ExQ1: [26 October 2020]**Responses due by Deadline 2: Monday 23 November 2020**

ExQ1	Question to:	Question	Response by North Somerset Council (as LPA)
GC General and Cross-topic Questions			
General			
GC.1.1	<i>Construction Phase</i> The Applicant	<p>The construction programme is set out in paragraph 4.6.1 of Environmental Statement (ES) Chapter 4 [APP-099] has work commencing in Winter 2021-22, with opening in winter 2023-24. Given the delay in the start of the Examination since the acceptance of the Application in December 2019 and the current public health restrictions:</p> <ul style="list-style-type: none"> i) Confirm if there is any change to the anticipated programme, and if so, provide reasons for this and an updated programme. ii) Will this affect any of the assumptions in the ES particularly with regard to in-combination cumulative effects (and HRA in-combination effects)? <p><i>You may wish to combine the answer to this question with the answer to question DCO.1.17.</i></p>

Drawing
PORTISHEAD STATION CAR PARK
LAYOUT, LANDSCAPING AND NEW
BOULEVARD AND ACCESS PLAN
SHEET 2 OF 3

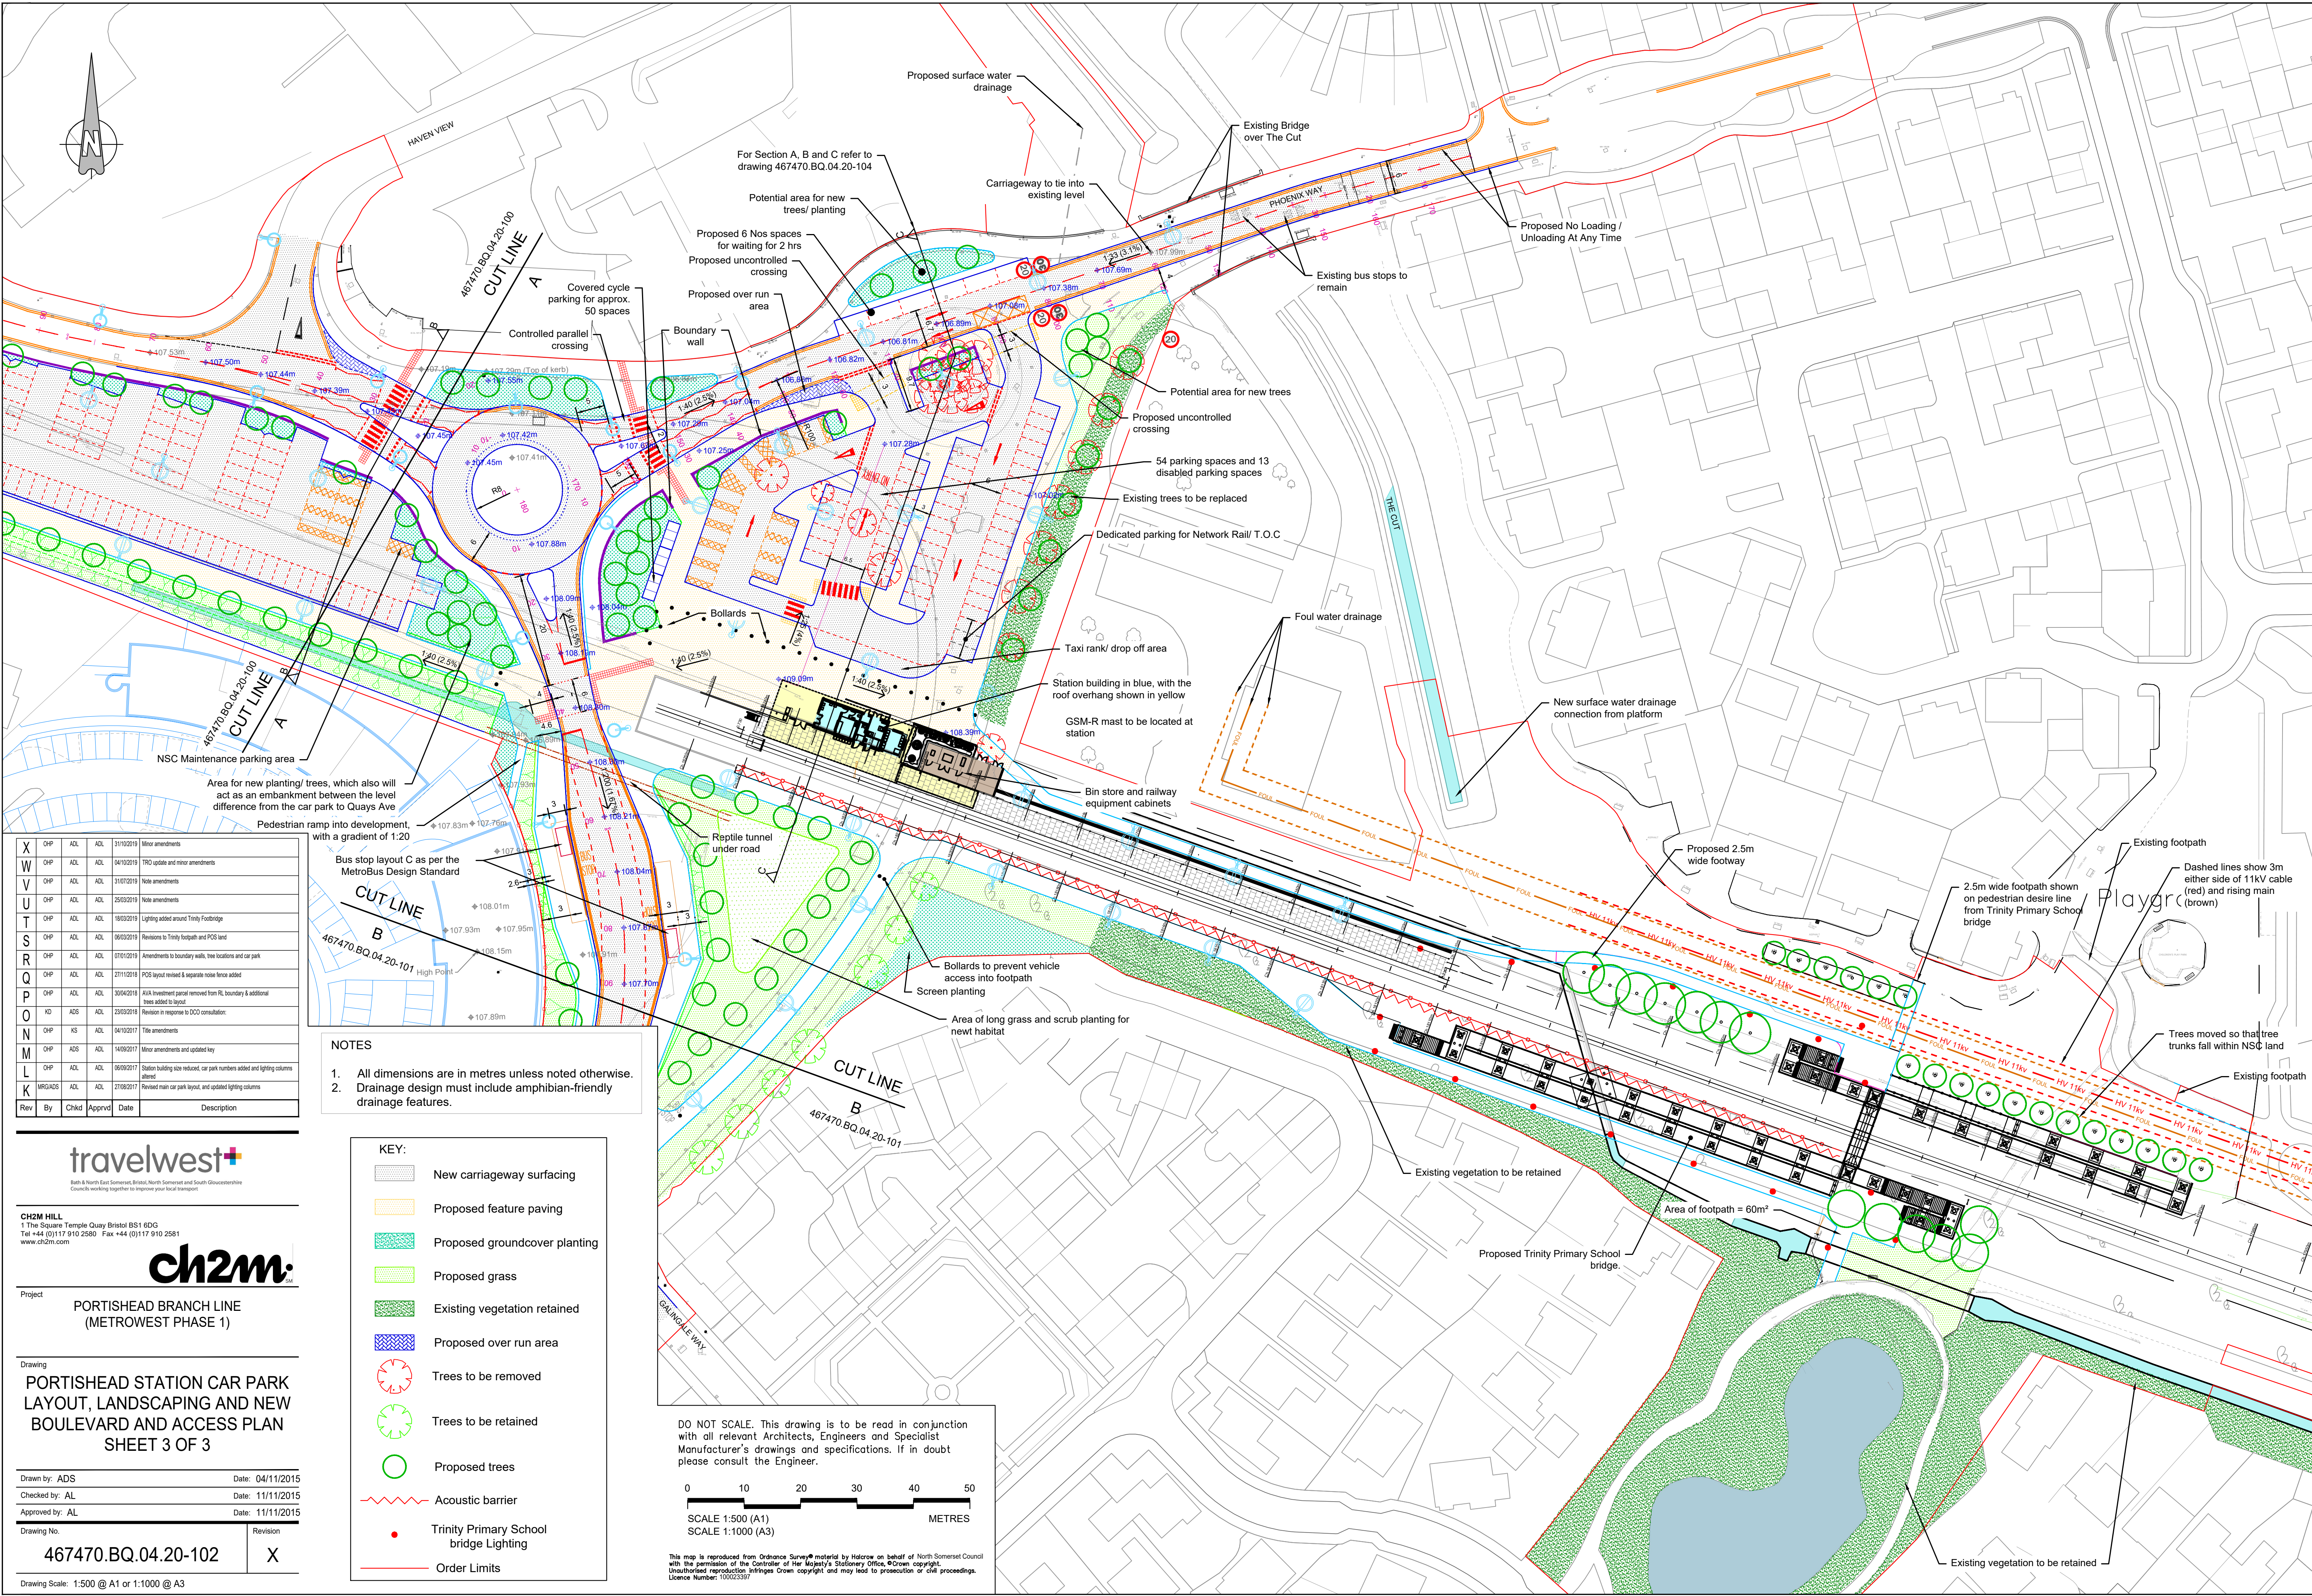
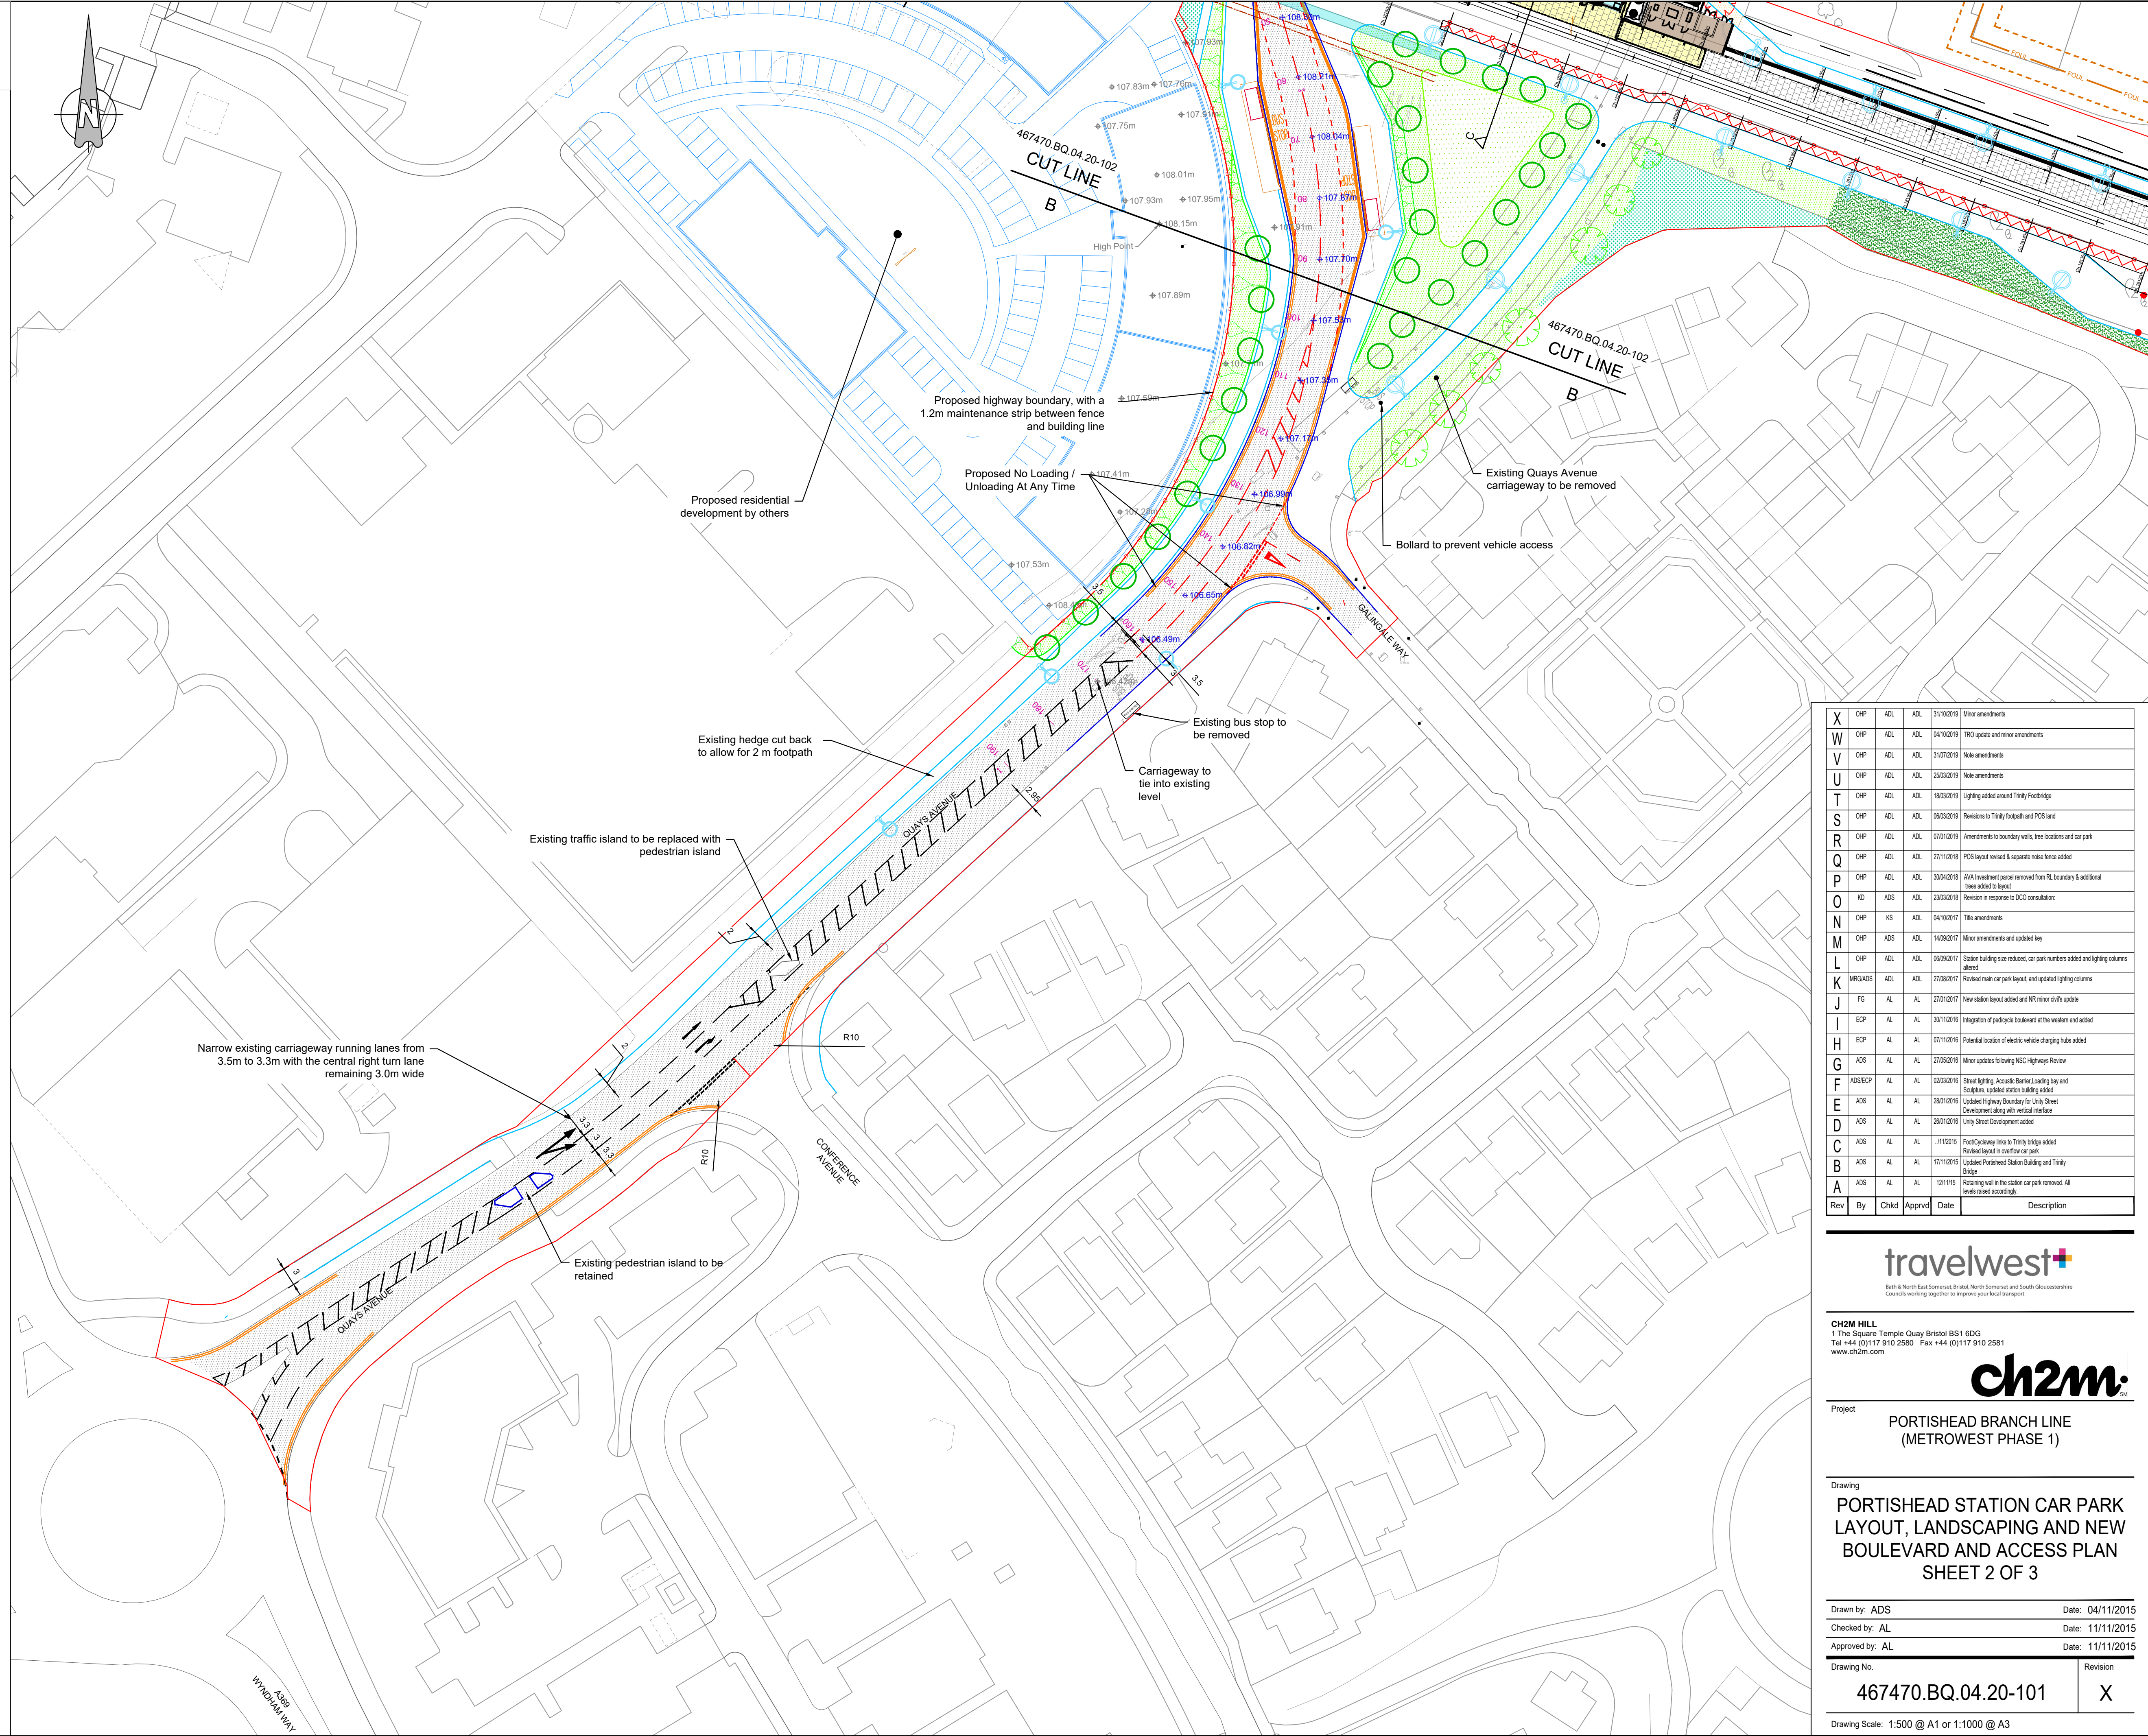
BIO.1.4	<i>Portishead Station</i> The Applicant	<p>Section 9.5 of the schedule of mitigation measures [APP-193] – Habitats are included in the Portishead Station Car Park layout and access plan [Environmental Master plan AS-026]. To ensure precision and enforceability should requirement 27 (Portishead Station) refer to the Environmental master plan?</p>	
BIO.1.5	<i>Train Speeds</i> The Applicant	<p>Paragraph 3.2.31 of the HRA [APP-142] states that the "<i>line speed on the existing operational railway between Pill and Ashton</i></p>
